Location: Betty Barn Slaidburn Road Waddington BB7 3JQ
Proposal: Regularisation of extension and conversion of barn to dwelling.
Grid Ref: 372371 444381

The Local Highway Authority (LHA) are in receipt of an application for the regularisation of extension and conversion of barn to dwelling at Betty Barn, Slaidburn Road, Waddington.

PROPOSED CYCLE
STORAGE

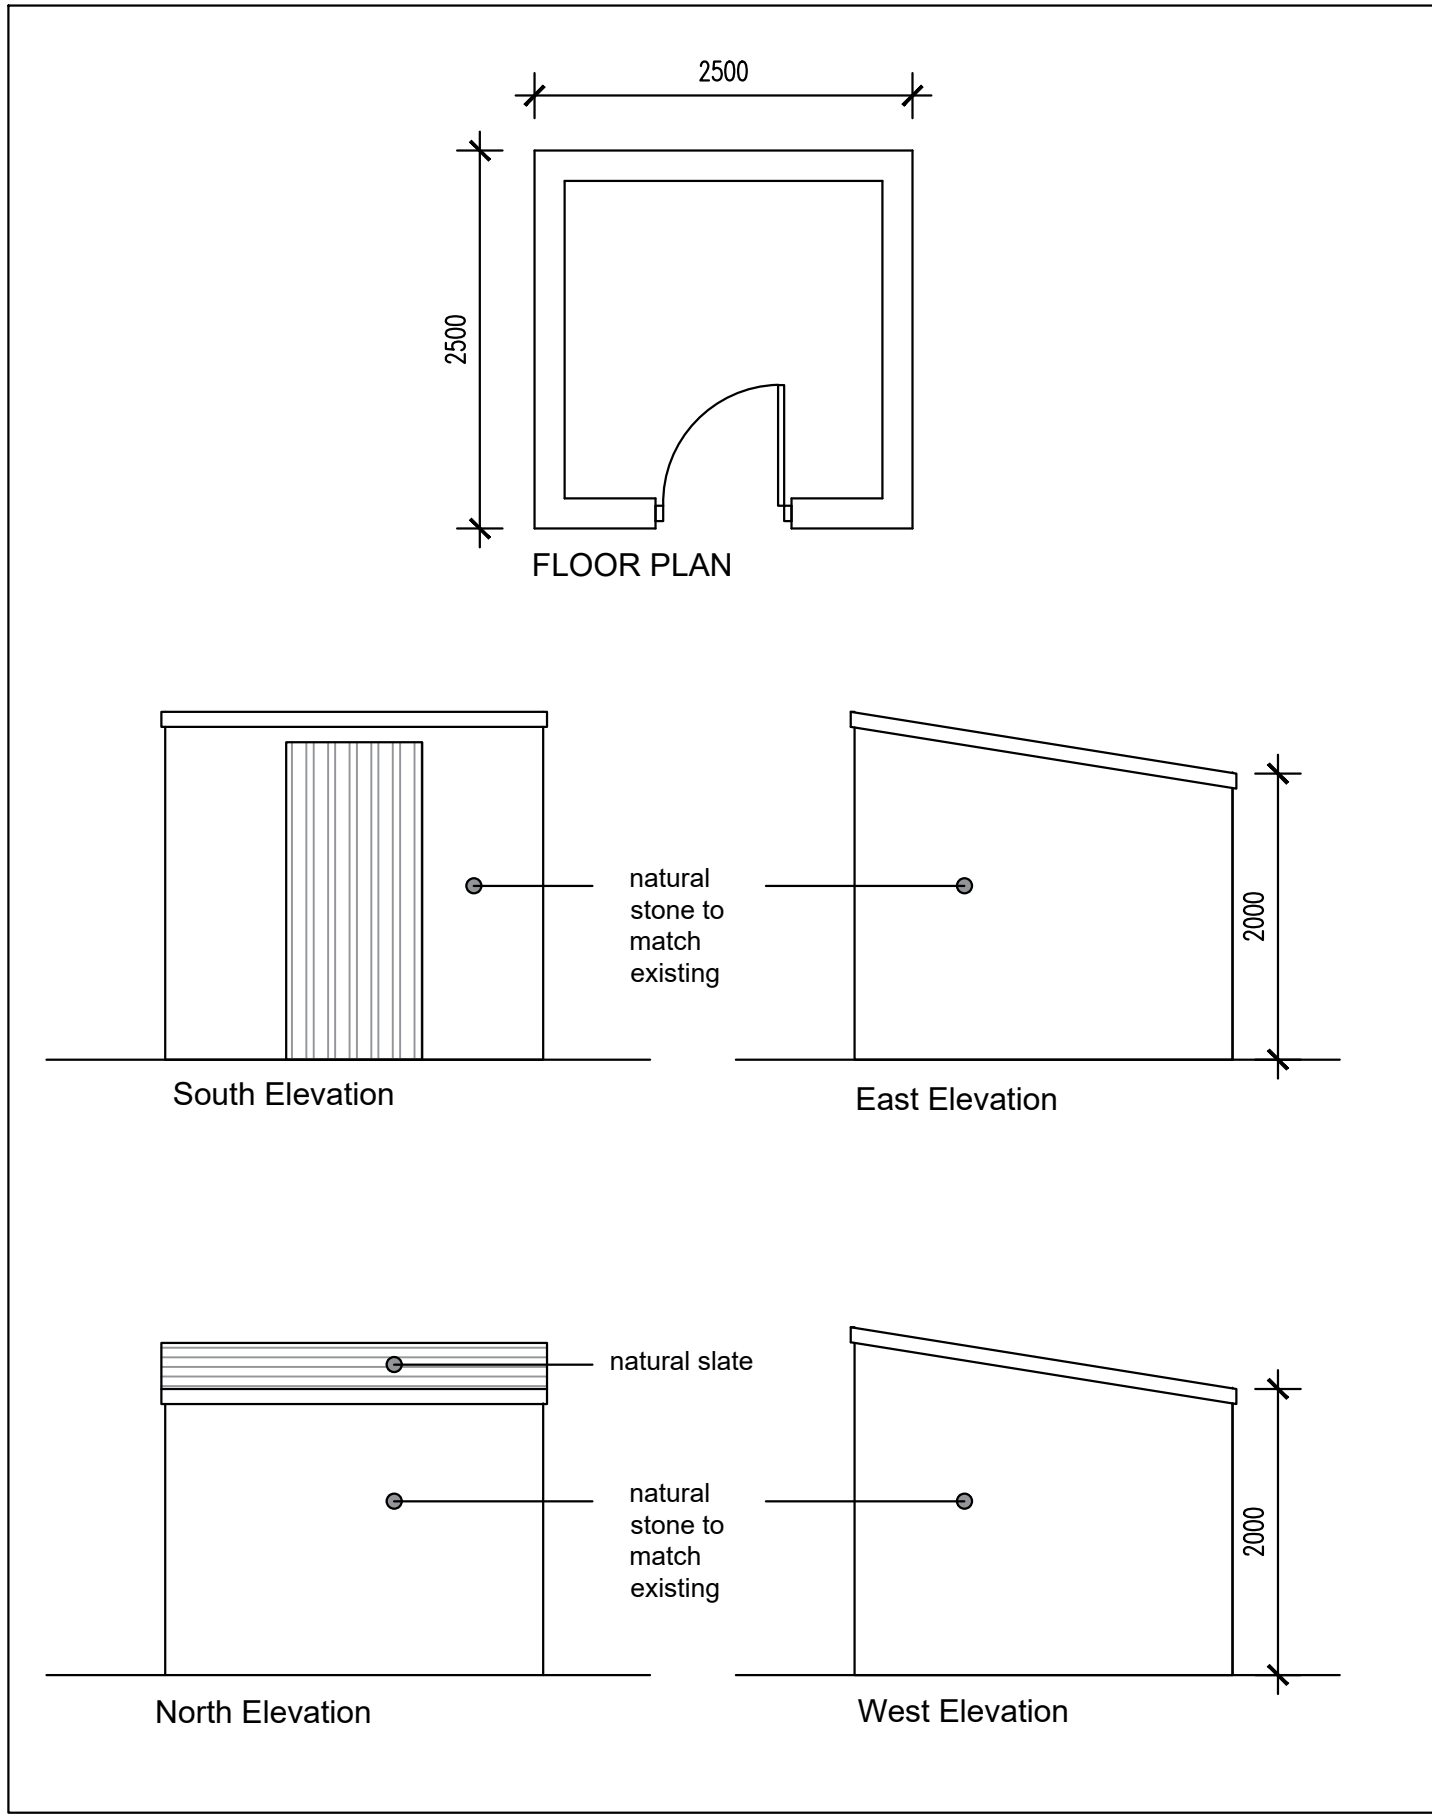
The LHA notes that the development includes covered secure cycle storage which ensures the provision and availability of adequate cycle parking for each resident and the promotion of sustainable forms of transport. Additionally, due to the nature of the application, it is recommended that a charging point for electric vehicles is included in the development to promote sustainable modes of transport. The DfT guidance regarding Electric Vehicle Charging in Residential and Non-residential buildings states charge points must have a minimum power rating output of 7kW and be fitted with a universal socket that can charge all types of electric vehicles.

6. The cycle facilities shall thereafter be kept free of obstruction and available for the parking of bicycles only at all times.
